From: Samantha Allen
Sent: 14 December 2018 10:55
To: 'gabriel urseanu'
Subject: RE: AW//270/18/DOC - 26 Christchurch Crescent

From: Samantha Allen [REDACTED]
Sent: Wednesday, December 5, 2018 3:45:32 PM
To: [REDACTED]
Subject: AW//270/18/DOC - 26 Christchurch Crescent

Untitled

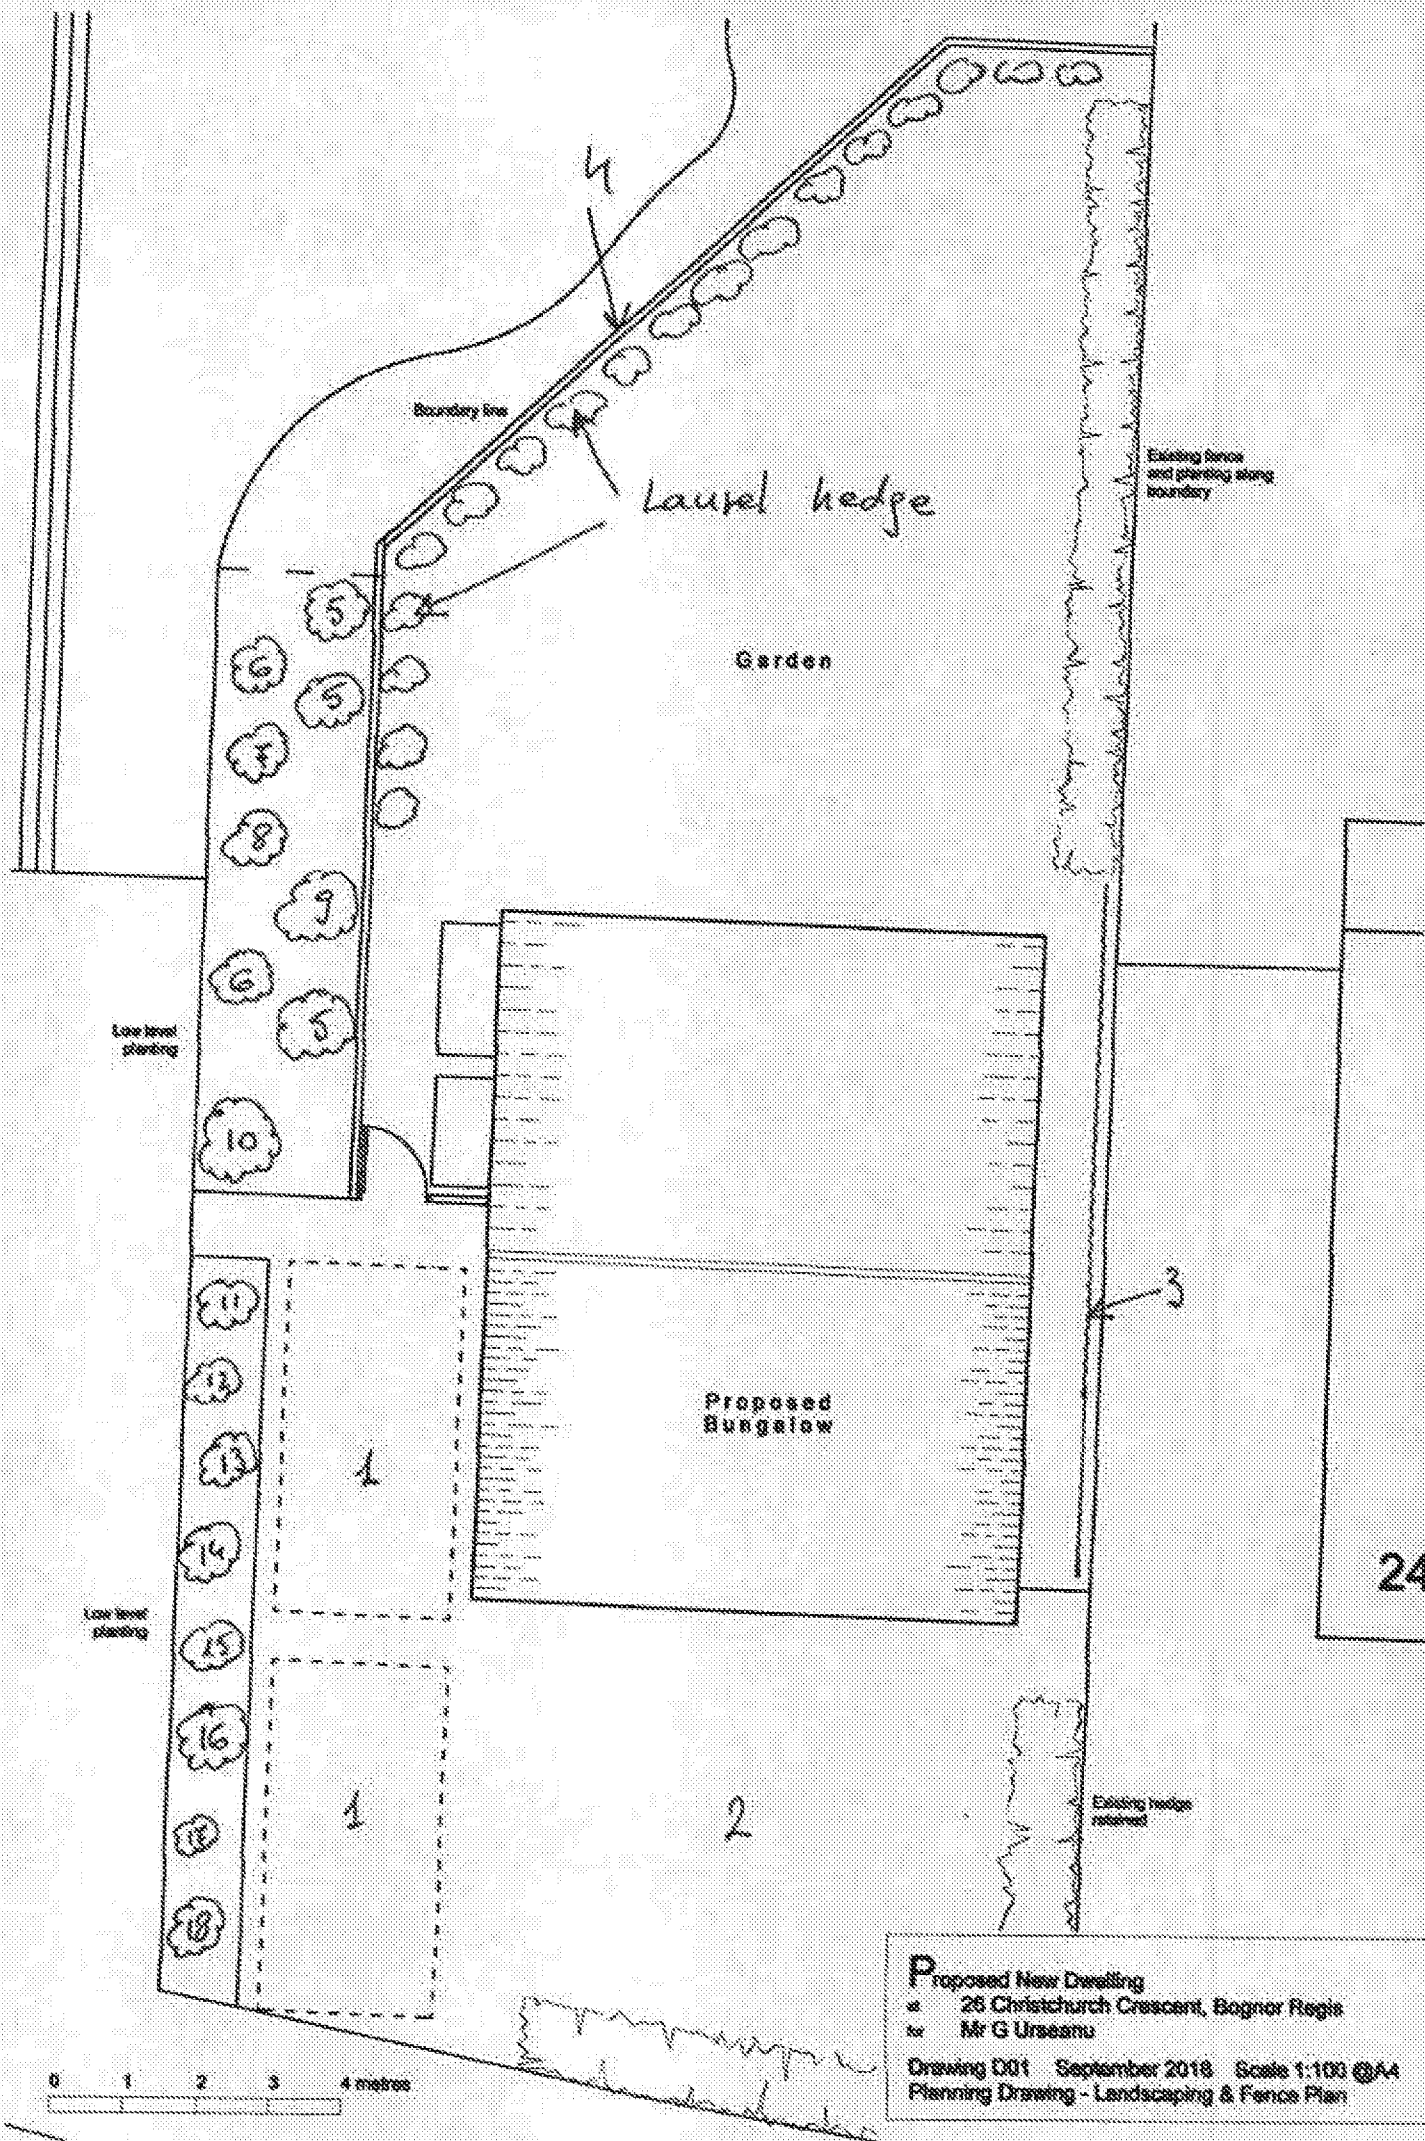
"The plant species choice detail for this location is suitable, however I still require clarification re the proposed planting with actual plant numbers, planting density and size at time of planting. This is needed for all the new planting detail and particularly required for the laurel hedge proposal."
